Application No: FG/155/25/PL

Site Address: Land between 11A The Grove and 30 Brook Lane Ferring BN12 5HZ

Description of works: Erection of 1 No 1-bedroom self build house with associated parking & private outdoor amenity space. This application is in CIL Zone 4 and is CIL Liable as a new dwelling.

A :: Block Plan
01 scale: 1:200

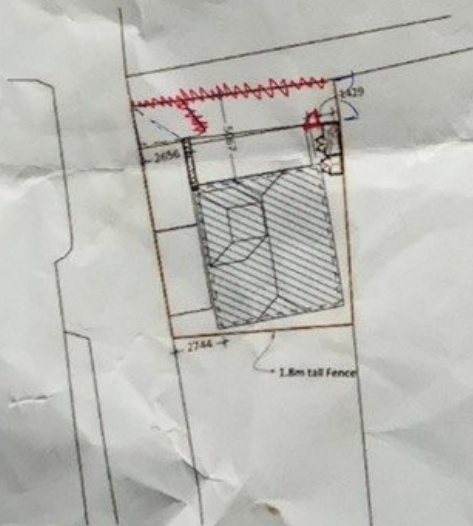
This is a contrived design trying to fit a dwelling on a site that is too small and out of place with the other dwellings in the grove and surrounding estate. The site plan is not correct as the applicant owns freehold of 26/28 brook lane and has not been shown in blue on site plan. The development does not meet your design standards in many ways the surface water drainage on this tight site with a sunken ground floor will have to go to foul sewer no room for Suds drainage as specified. The parking shown dominates the house frontage. The house could be classified as 2 bedroom as study is bedroom size. The back garden will not be private but overlooked. The building is in front of building line of the grove. The side front gates and front faced are 1.8m high and out of keeping. No consultation has been carried out by owner with affected neighbours. No overall height and external dimensions have been shown or accurate setting out dimensions on such a small plot. Having a sunken ground floor and internal steps does not comply with part M of the building regulations and ground floor wc is also to small under part M. The first floor bedroom windows are shown as fixed shut and opaque up to a height of 1.7m off floor when you scale drawings widow head is about 1.7m off floor means bedroom would have no clear windows or natural ventilation. The proposed gates and back garden fence would make it impossible for me to park my car and result in 2 cars having to be parked on the road which has very limited parking. If developments like this were allowed around the private estate it would completely ruin the estate character.
